Charlotte Department of Transportation

Memorandum

Subject: Rezoning Petition 08-086: Located on both sides of Victoria Avenue north of West 4th Street Extension and east of Johnson and Wales Way (revised 6/20/08)

SCHEMATIC SITE PLAN
 GATEWAY VILLAGE WESTERN ANCHOR PROJECT
 CHARLOTTE, NC

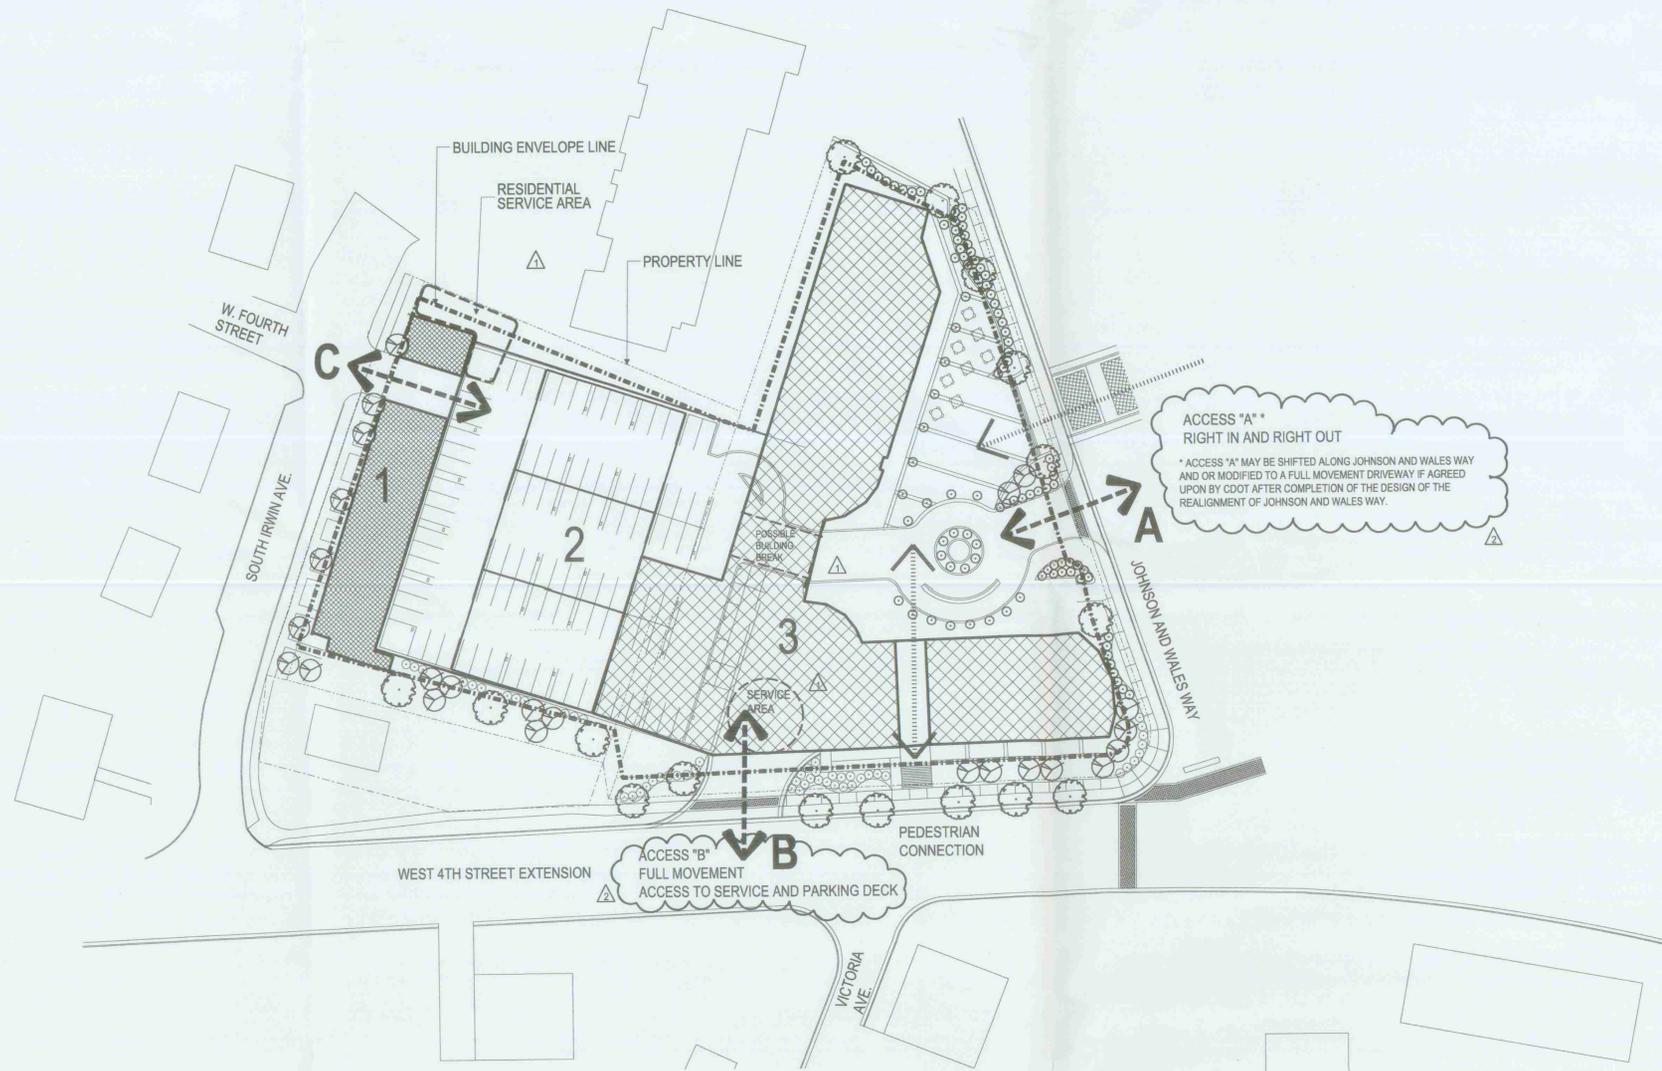
2. Due to the planned raised median, a full-movement access will not be approved on Johnson and Wales Way. We can support a driveway limited to right-in/right-out movements provided that the driveway is moved to a location towards the northern portion of the site and in advance of the proposed mid-block crosswalk location as determined by CDOT. As proposed, the driveway is located to close to the 4th Street intersection and needs to be in advance of the proposed crosswalk. *(Previous review comment)*

3. CDOT can support a full access driveway on 4th Street and South Irwin Avenue. The driveway on 4th Street needs to align with Victoria Avenue. If the driveway cannot be aligned with Victoria Avenue, then it needs to be located at the site's western property line. The proposed parking deck needs to be served by the driveways from both 4th Street and Johnson and Wales Way. *(Previous review comment)*

Sheet:
RZ-2

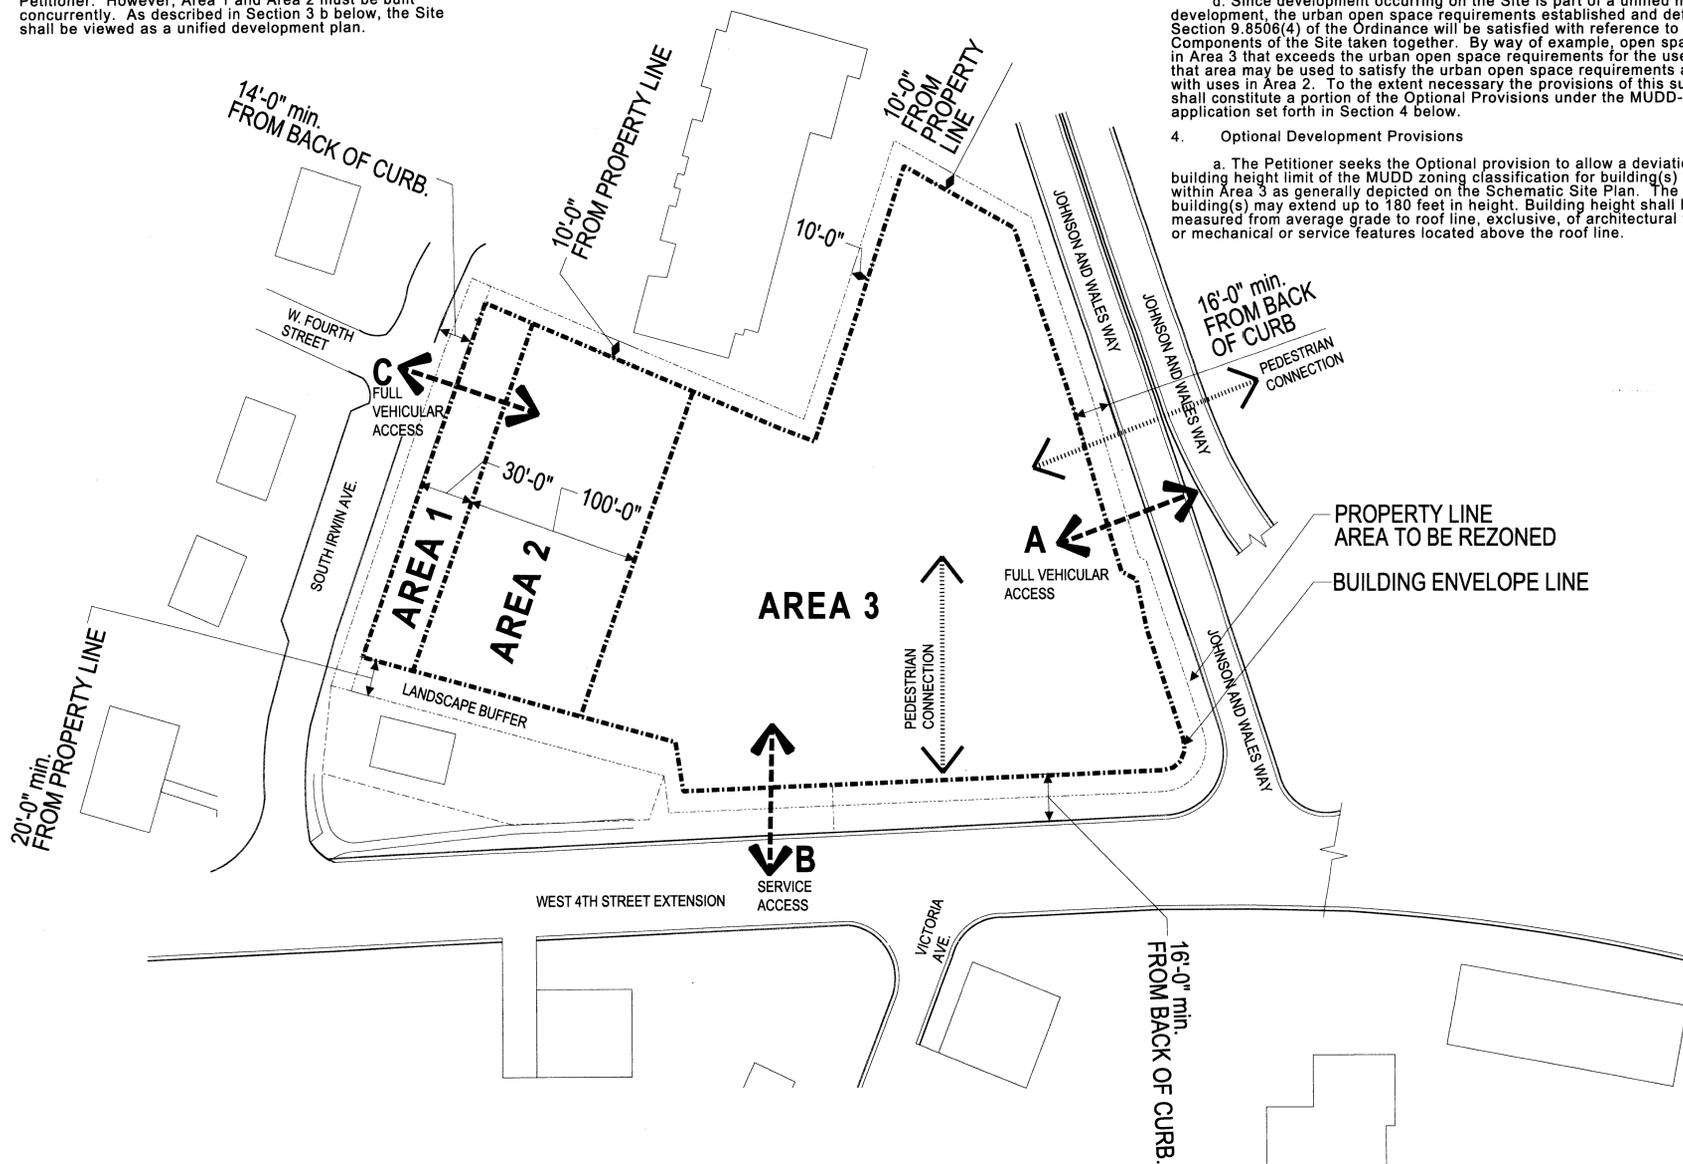
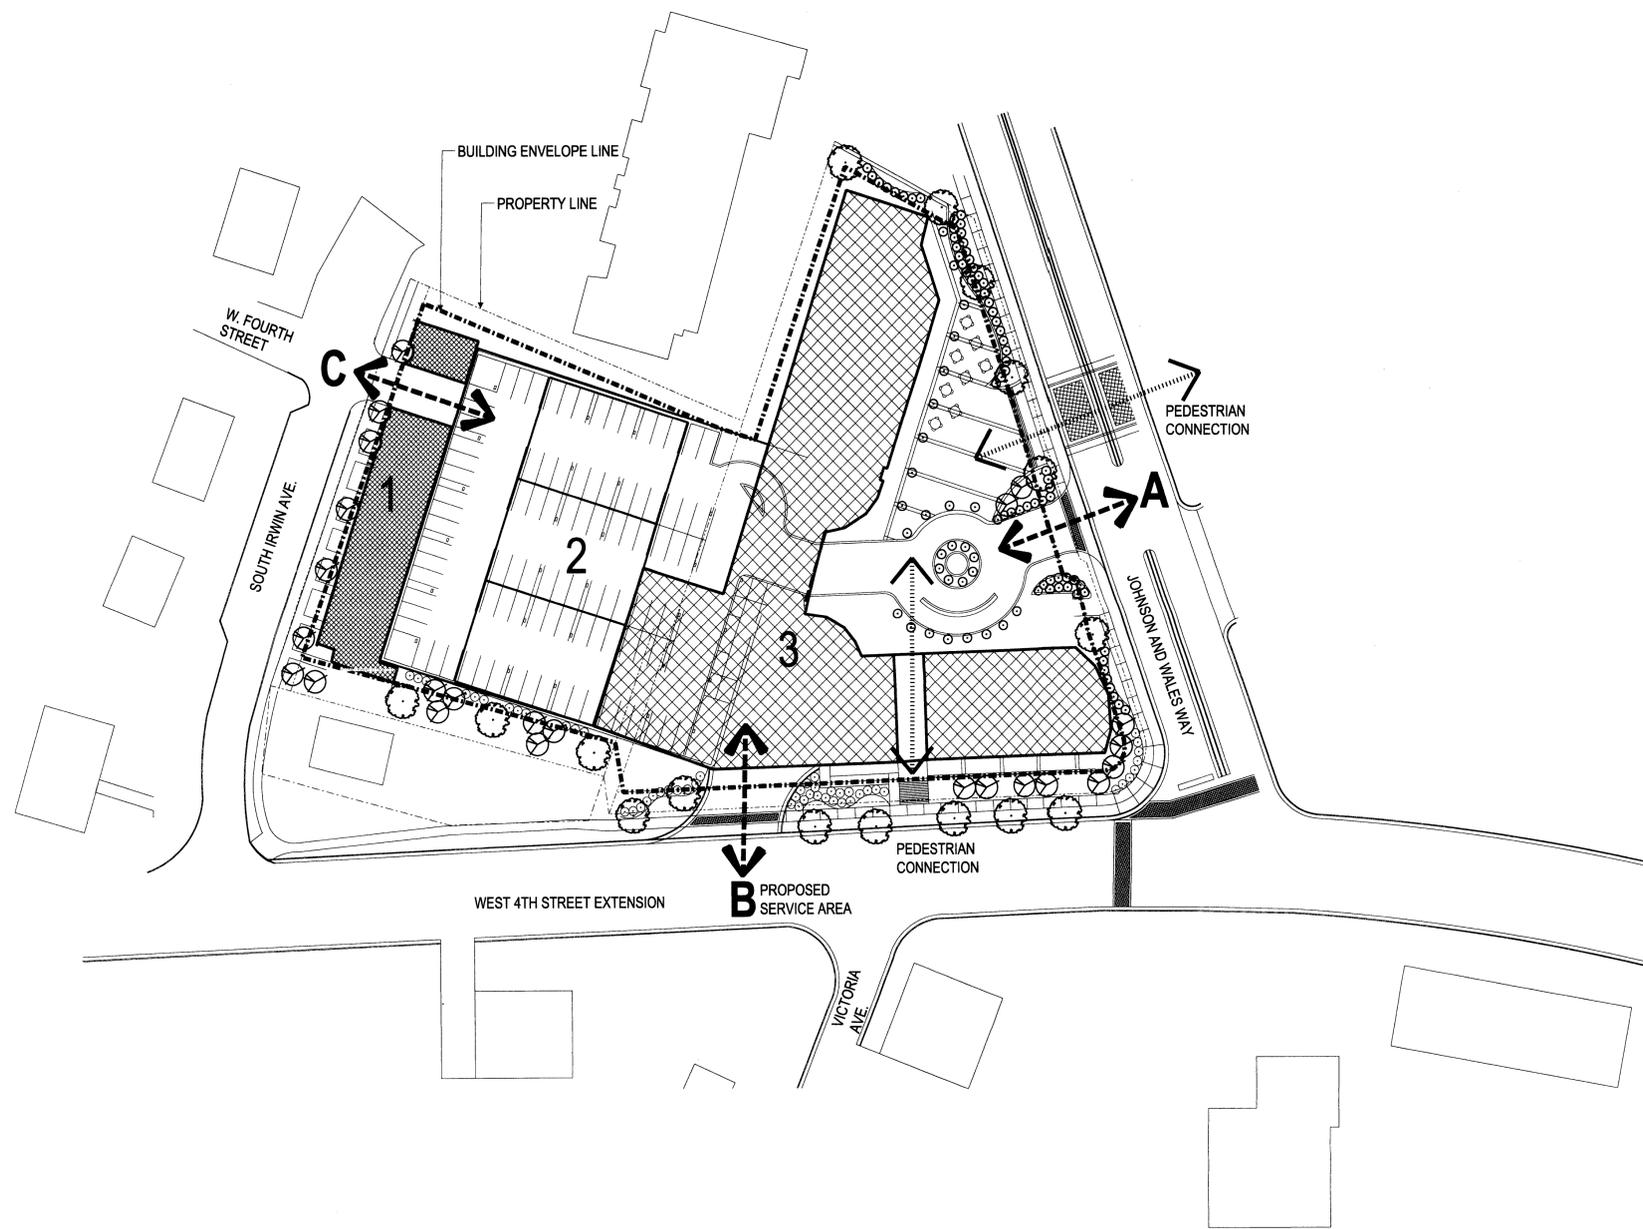
4. Irrespective of the conceptual nature of the proposed site plan as indicated in Note 1, the petitioner/developer needs to revise the site plan in accordance comments 2 and 3 above. These requirements will not change and need to be conceptually designed into the proposed development.

5. We will not support/approve the maneuvering of service vehicles in the W. 4th Street right-of-way as requested in Development Standard Note 4b. This note needs to be deleted from the site plan.
